Sunningdale
West Drive
Angmering
BN16 4JE

December 4th, 2017

Objection to Arun District Council Planning application: A/190/17/HH

DRAWING	PROPOSED SITE PLAN AND ELEVATIONS																						
Date	October 2017	Drawn By	PJC																				
Scale	1: 200 - 100 @A3	Iss. App. By	DKC

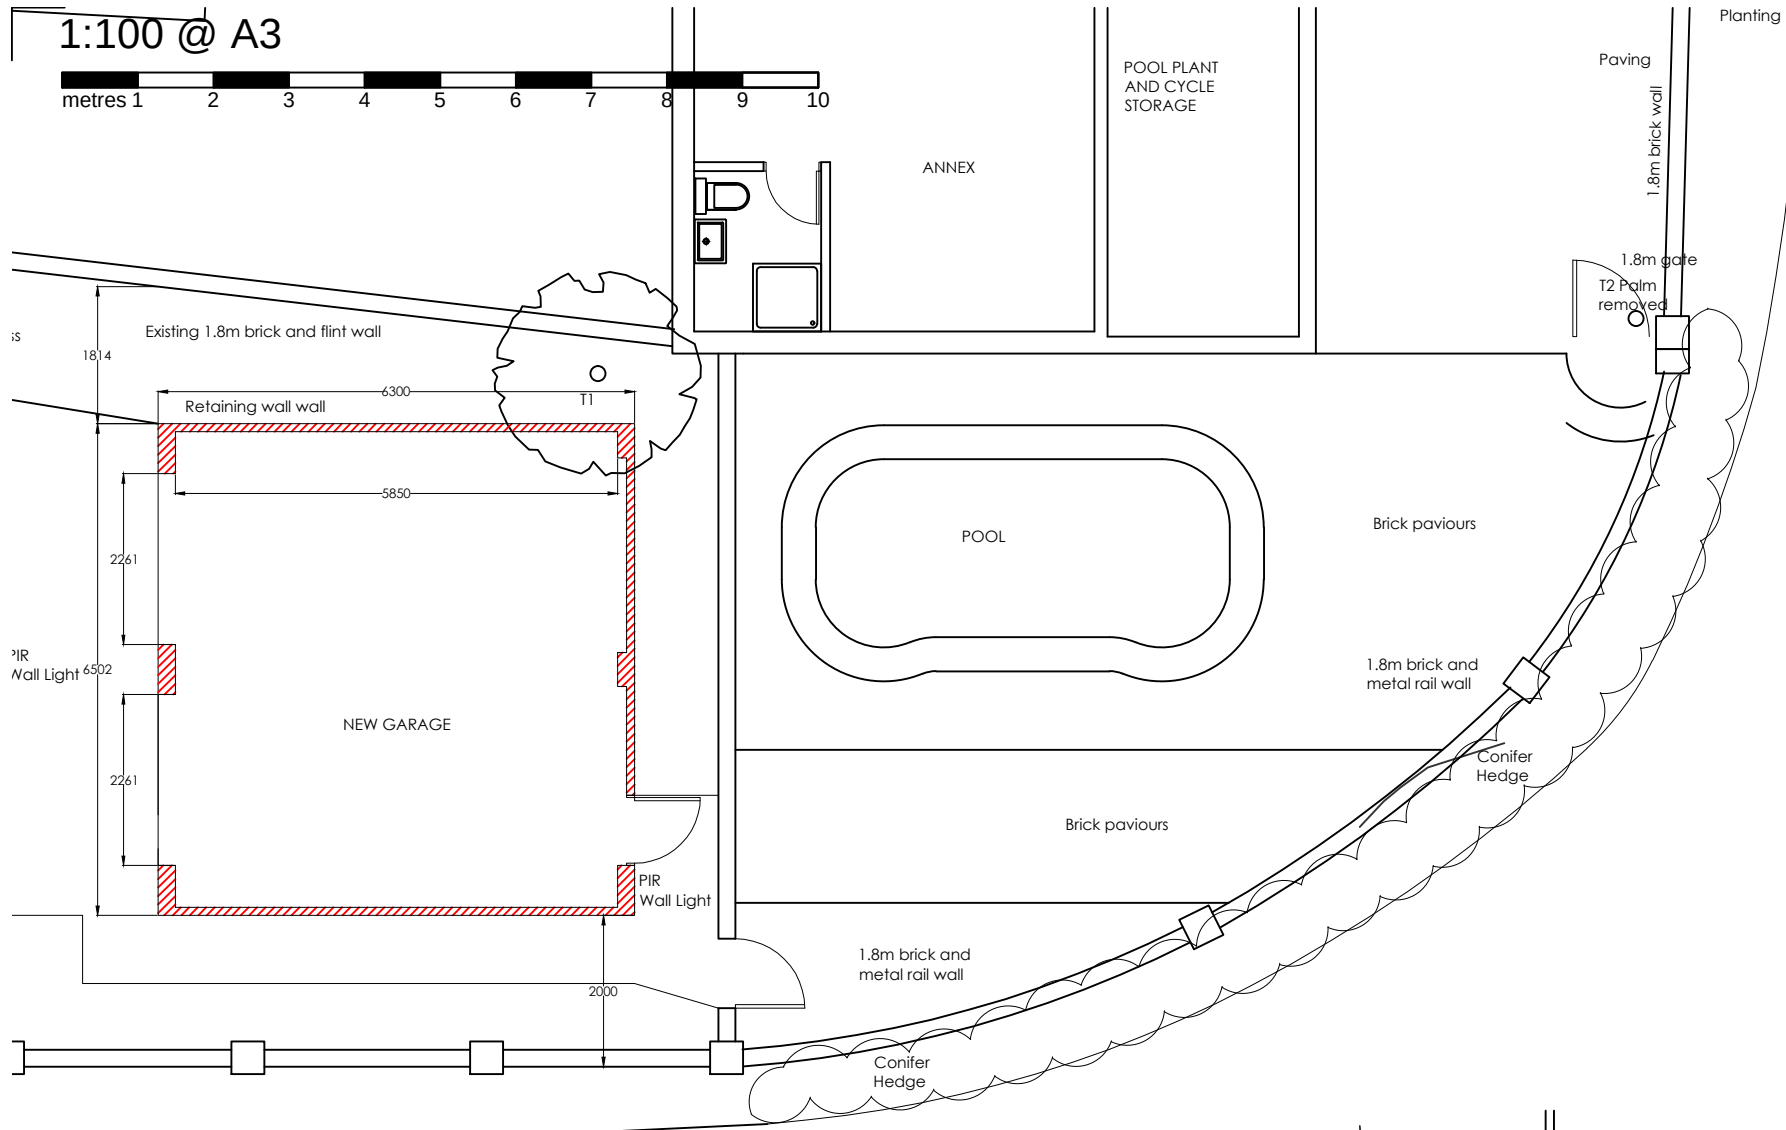
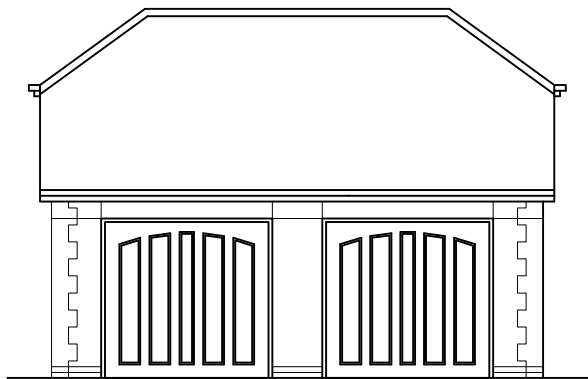
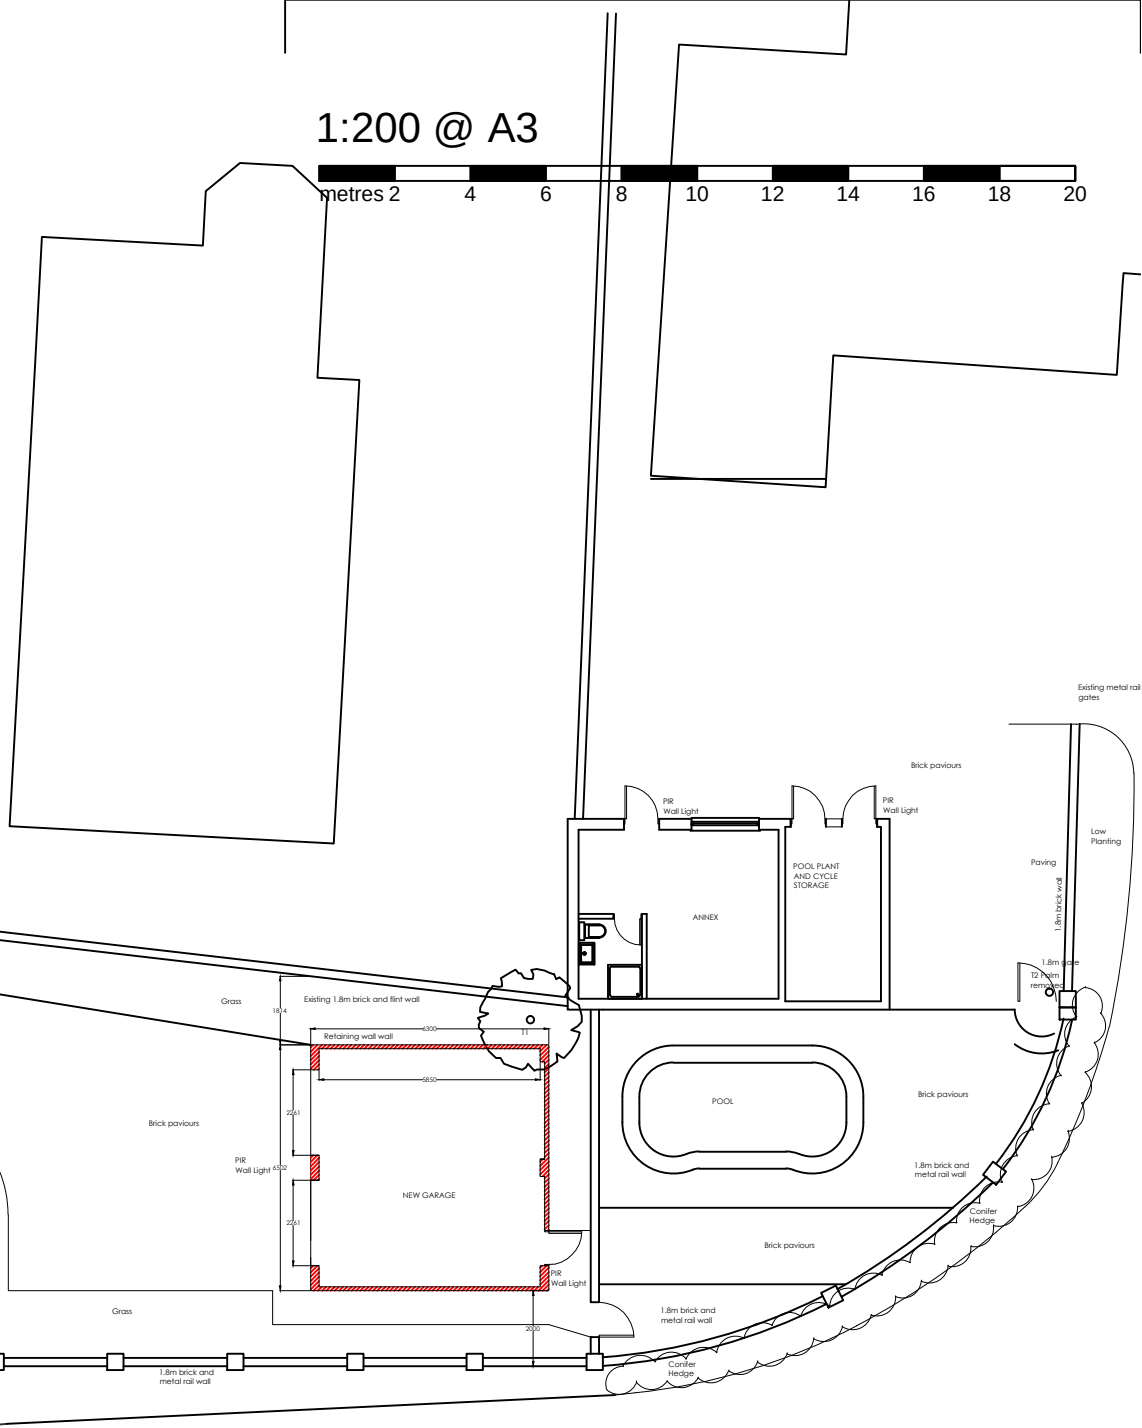
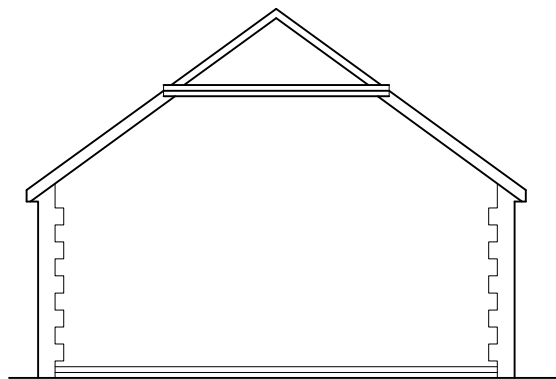
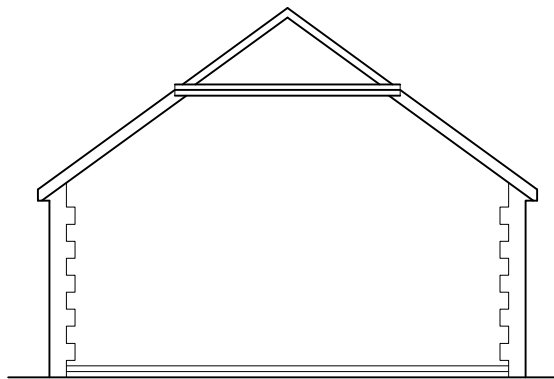
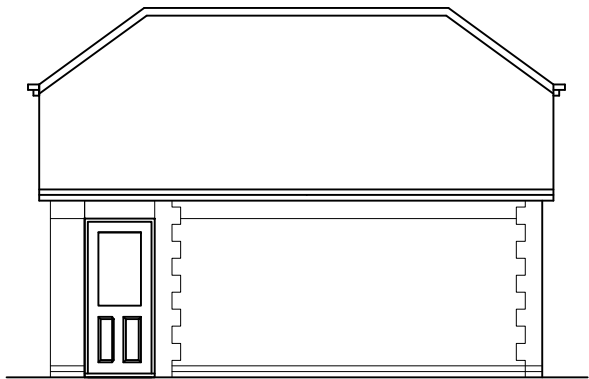
8. Construction of this garage block will have a direct detrimental impact on my property through loss of amenity through the significant height and mass of the structure creating shadow and loss of openness. This is identified and readily acknowledged in the planning application, which is strangely silent on the exact height of the structure; **HD5 & GEN7** refer.

9. As noted, the height of the proposed structure is not indicated, but from the drawings, and the excavation that will be necessary to level the area, it is disproportionately tall. Concern exists that once constructed use for other purposes including accommodation similar to unapproved changes to original garaging on the property, will not be preventable.

10. Existing walling is approximately 65cms with the remainder wide spaced iron railings between brick pillars. The erection of tall entrance gates and introduction of hedging will only serve to further reduce the appearance of openness in this area.

11. Erection of the block in part on the plot at its highest elevation will necessitate major excavation works and earth removal to create a level area for the construction, posing a significant threat of disturbing the foundations of my property, which sits immediately adjacent and at a much higher elevation. This will be further exacerbated through the excavation and earth removal required along the remainder of the western side of the parcel to create the level surface for access.
